RE: Alternative Lighting Plan

Parcel Nos: 5405000055, 5405001004

Request: A request by Rowley Ventures, LLC, for an alternative lighting plan pursuant to 6.2.3.E of the Land Development Code (2022) (LDC):

## LED PARKING LOT LIGHT

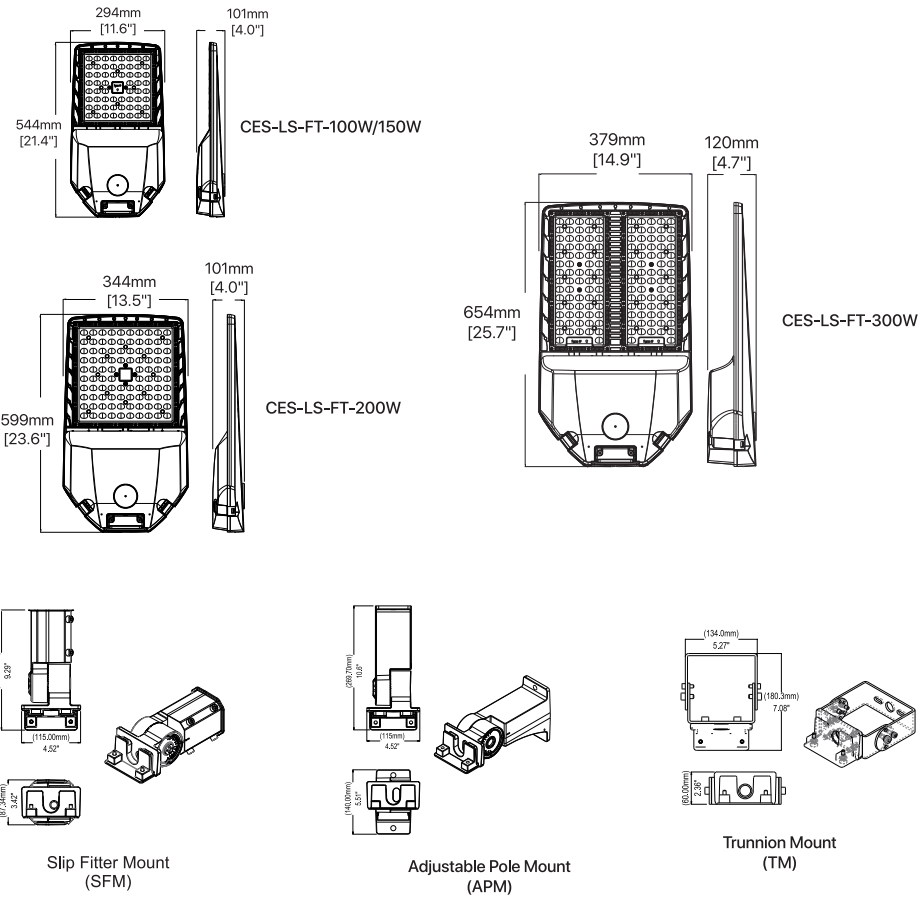
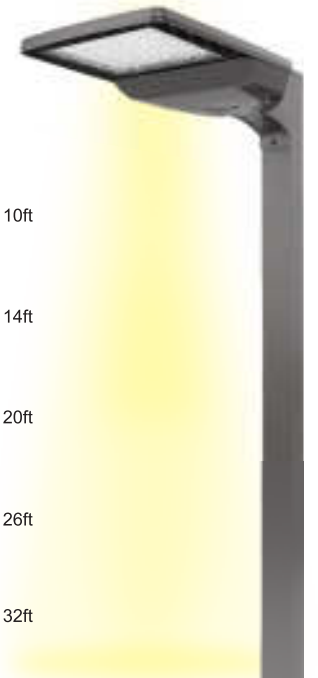
Glare and light trespass is occurring. Several light fixtures are angled above horizontal. See lighting plan for additional notes.
